Rezoning Transportation Analysis
Petition Number: Insert Zoning Petition #2021-201
General Location Identifier: Tax ID 12709305

From: Brandon Brezeale, PE
Brandon.Brezeale@charlottenc.gov
704-432-5561

Reviewer: Walta Blackmon
Walta.Brumskine@charlottenc.gov
704-432-1556

Date	Description
12-23-21	First Review (WB)
02-21-21	Second Review (WB)

SHEET NAME
REZONING SITE PLAN

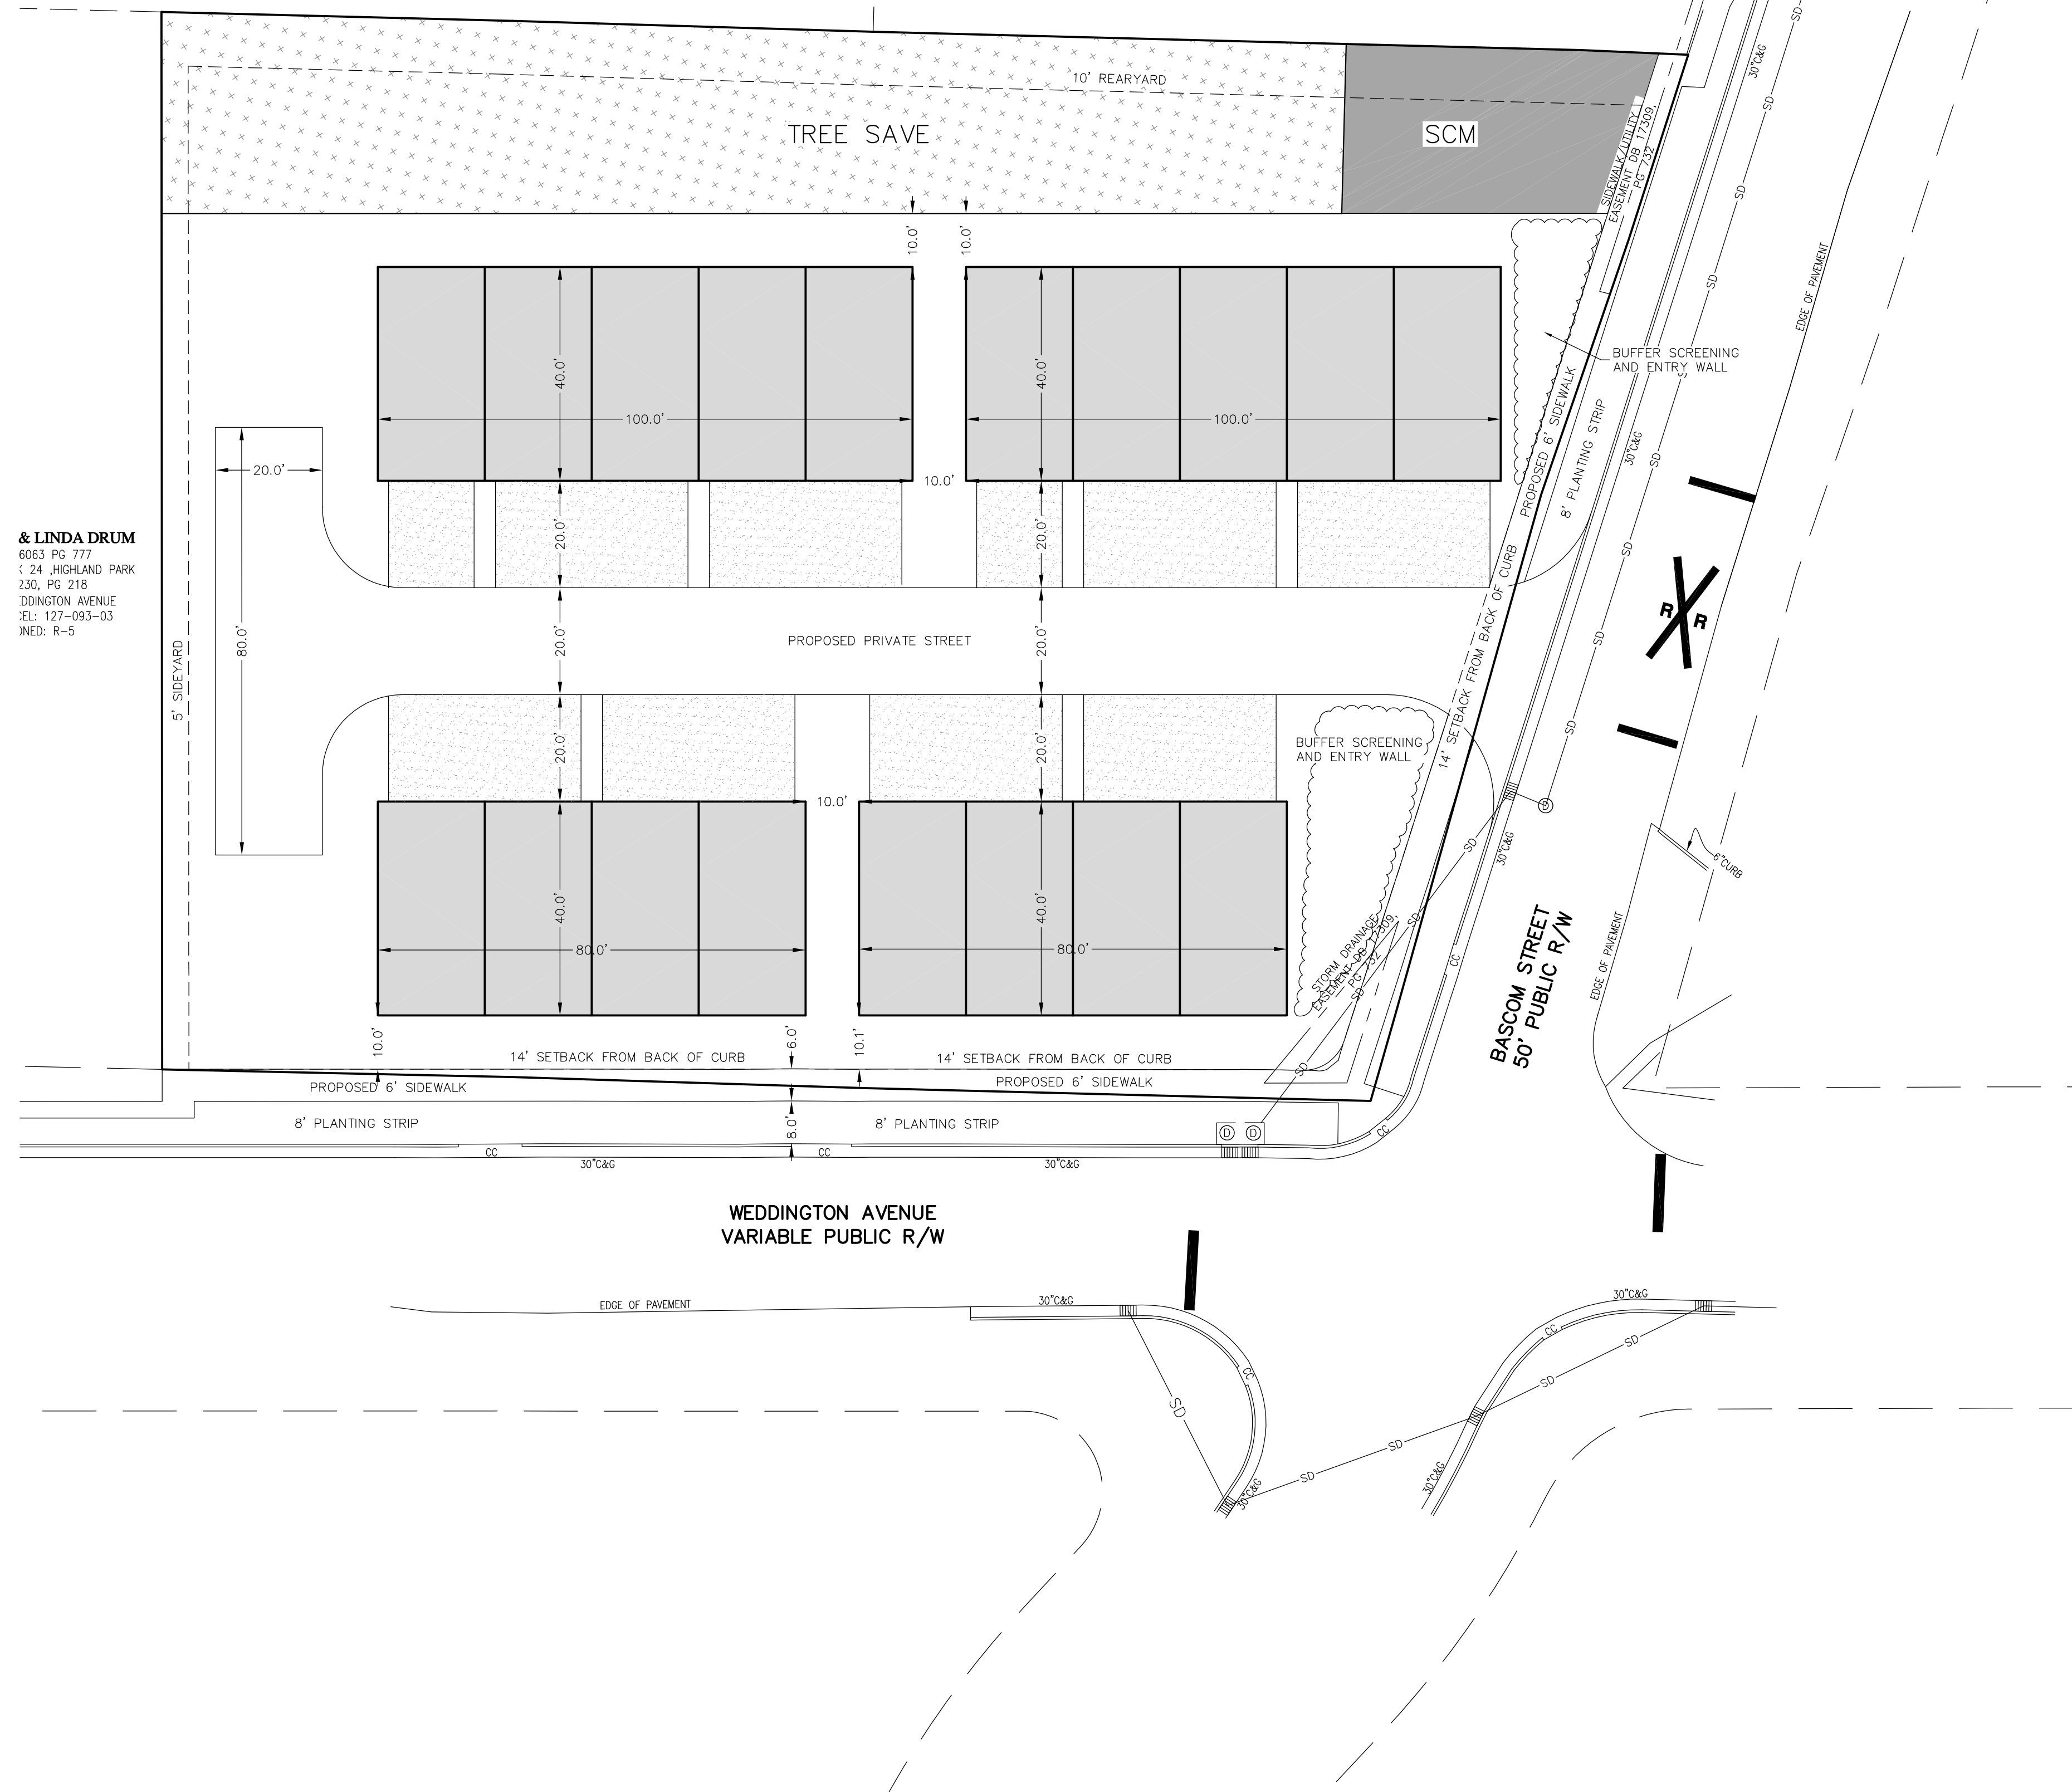
- Comment Clarification (Unaddressed Comment):** Revise site plan and conditional notes to commit to dedicate a 36-foot right-of-way from the road centerline on Weddington Avenue and Bascom Street. The site plan shall label and dimension the right-of-way from the road centerline.

8. Add a site plan note specifying dedication and fee simple conveyance of all rights-of-way to the City before the site's first building certificate of occupancy is issued. CDOT requests rights-of-way set at 2-feet behind back of sidewalk where feasible.
9. Add a site plan note specifying that all transportation improvements will be approved and constructed before the site's first building certificate of occupancy is issued. The petitioner may phase transportation improvements if said improvements and phasing are explicitly described in site plan notes.
